Response to Submissions

SSD 5373

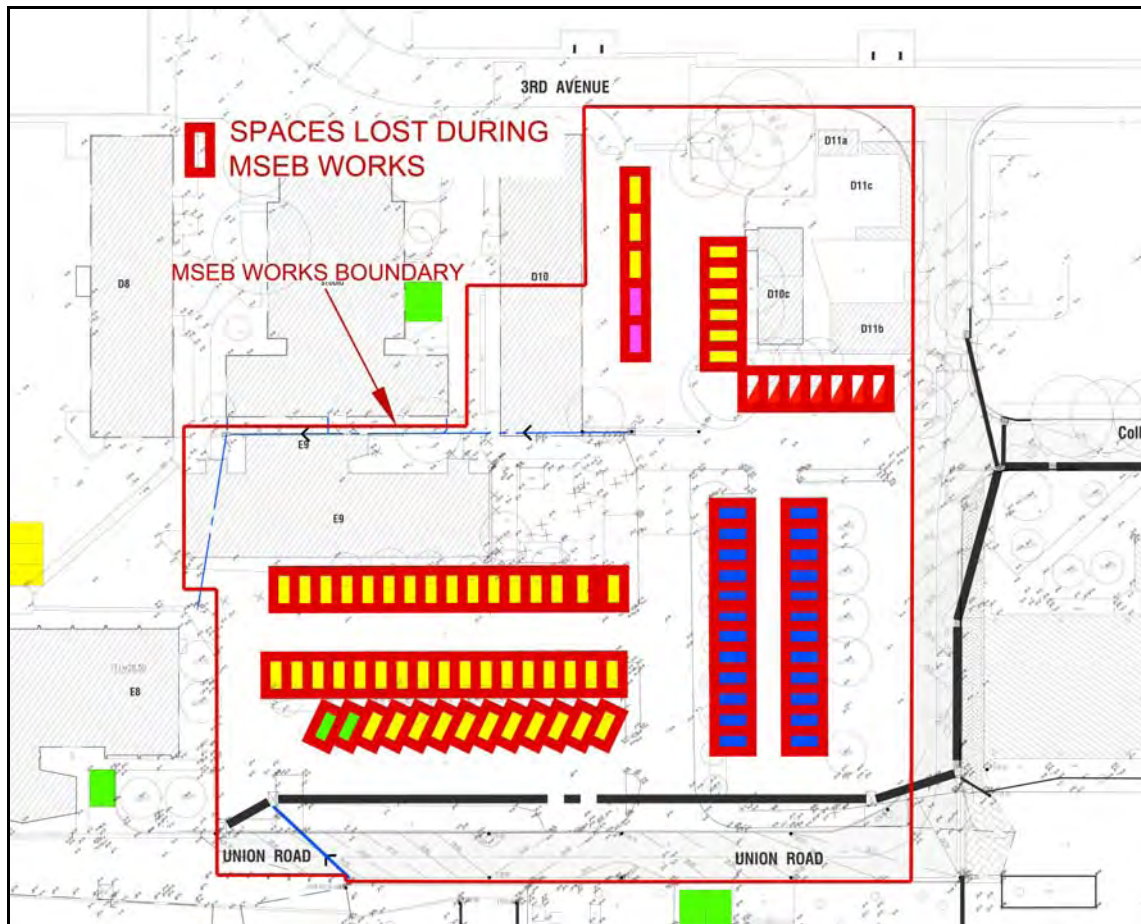
Parking Issues	
The proposed development will require the removal of 84 car spaces on lower campus including 2 disabled spaces and a carshare space operated by GoGet Carshare. The traffic and parking study attempts to justify this by noting that the total amount of parking spaces on campus will actually increase by 1 space when taking into account recent redevelopments around the Campus. This approach fails to recognise the increased parking demand generated by the redevelopment within the Campus and the significant reduction of parking availability to permit holders and visitors.	As demonstrated at Figure 6 of the Response to Submissions report, at the completion of the MS&E Building in 2014 there will be a net gain of 19 car parking spaces on the Campus when compared to what was available in 2011. TTW has revised their parking calculations to reflect these figures, and to respond to Council's concerns around the data used to establish the parking demand generated by the new building (refer to the Parking Statement at Appendix D). The level of car use among staff has been taken from the 2012 UNSW Survey - Travel Trends (see Appendix B as part of Traffic and Parking Report submitted with the EIS). The data demonstrates that 41.1% of staff travel to and from the University as car drivers. The rate of 44% that Council has used includes car passengers and motorbikes, which is not an applicable consideration when determining parking demand. However, due to staggered working days and hours, holidays, illness and other absenteeism, not all staff are on the Campus at any one time. On this basis, TTW has applied an attendance rate of 80%, which is supported by the University's survey data. Based on these figures, and the immediate population increase resulting from the development (i.e. 24 staff), there would be an initial maximum car parking demand of 8 spaces (i.e. $0.41 \times 24 \times 80\% = 8$ spaces). This immediate requirement will be met (and exceeded) by the additional 19 spaces that will already be available on the Campus by the end of 2014 when the new MS&E Building is completed. The parking demand generated by up to 144 future staff (if calculated based on current levels of car usage) would result in a need for 48 spaces (i.e. $0.41 \times 144 \times 80\% = 48$ spaces). This compares to Council's calculation of 63 spaces which did not take into account staff attendance rates or the reduced proportion of staff that travel to the Campus as car drivers. However, this parking demand is only accurate if the full population growth were to occur immediately. As the maximum population would not be reached for at least 5 to 10 years (if at all) TTW has used existing survey data to predict future travel patterns. As outlined in TTW's original report, the survey data demonstrates that there was a 12% decrease in car drivers between 2007 and 2012. This decline is acknowledged by Council in its response. Based on these trends, TTW has calculated the future parking demand on the assumption that 35% of staff will travel

The loss of one carshare space is not consistent with the sustainable transport objectives and at minimum this space shall be relocated elsewhere on the Lower Campus, with additional share spaces considered. The loss of the carshare space is not acknowledged in the accompanying Traffic and Parking Report.	The car share space has been temporarily relocated in front of the MS&E Building, opposite the Law Building. As the University Terraces development is now complete, it will soon be moved to a permanent space opposite the entrance.
The accompanying traffic and parking study states that the new building will accommodate up to 700 staff but claims a majority of these will be relocated from elsewhere within the Campus. Only 24 additional staff will initially result increasing to 144 at its final completion. On what basis is this calculation determined is not explained in the Environmental Impact Statement. It is also claimed the building will not contribute to additional student numbers.	Relevant to the consideration of parking, it is noted that Council has raised concerns around the University's calculation of the future building population. The building will have a total capacity of approximately 700 people when fully completed and occupied, comprising 540 staff and 150 students. As outlined in the EIS, the building will not result in any additional students on the Campus, either now or in the future. Of the 540 staff who will occupy the building, the existing School of Materials Sciences has a population of 276 which will be relocated into the new building. This figure is based on existing staff lists and post-graduate student enrolments. As noted in the EIS, the building will not be fully occupied immediately. The immediate building population from the basement to level 4 will be 300 (based on an average maximum population of 80 people per floor) resulting in an immediate increase of 24 staff (i.e. $300 - 276$). Based on this same rate of 80 people per floor, levels 5-7 would result in an additional population of 240 people. However, as a result of the University's decanting protocols and strategy, it is assumed that only 50% of these would be additional / new population, with the remaining 50% comprising existing staff moving from elsewhere on the Campus. This results in a shell capacity of 120 people, and a total new capacity of 144 people (i.e. 24 immediate + 120 future).

Issue Raised by Agency	Proponent's Response
The proposal will create a total parking deficiency of 147 spaces which takes into account the existing 84 spaces removed by the proposal as well as the 63 spaces generated by the proposed development. This is grossly excessive and will lead to a chronic parking shortfall on lower campus and increase the impact on on-street parking in High Street.	Refer to above, based on the revised figures, the fully occupied building would result in a future parking deficiency of 21 spaces on the Campus (i.e. 40 (deficiency) – 19 (surplus on the Campus at the end of 2014) = 21 spaces). This represents only 0.8% of the overall parking provision across the Campus, which does not represent a “chronic parking shortfall” as suggested by Council. Council has also raised concerns that the parking shortfall will impact on the availability of on-street parking on High Street. The University notes that the very minimal shortfall in parking will not result in any perceivable additional demand for on-street parking. Further, on-street parking is beyond the University’s jurisdiction and is the responsibility of Council, as outlined in the UNSW Transportation Strategy in Figure 5.12 of DCP 2020. Council has also previously acknowledged the need to develop a precinct-wide approach to car parking, and has recognised that it is not solely the University’s responsibility to manage parking in the locality. This precinct-wide approach to parking is supported by Council’s Randwick Education and Health Specialised Centre Precinct Plan which calls for the consideration of future shared parking facilities in the area.

Figure 8: Proposed vehicle access to new MS&EB. The vehicle shown is a 19 metre articulated truck used for the delivery of Liquid Nitrogen. Waste vehicles are in the classification of medium rigid vehicles.

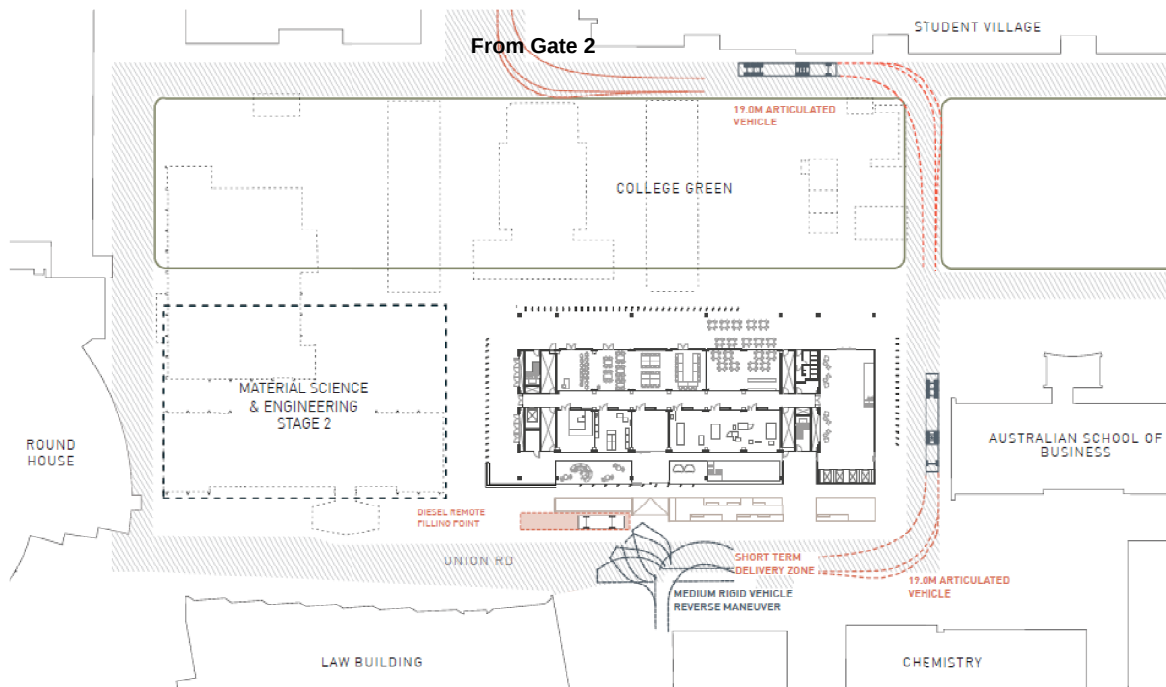
Waste Management	
Operation of the facility will generate a variety of solid and liquid wastes including biological wastes, electronic waste and chemical waste and requires a range of	Operational waste from the building will be managed in accordance with the University's existing Interim Waste Plan, and the UNSW Laboratory Hazardous Waste Disposal Guideline.
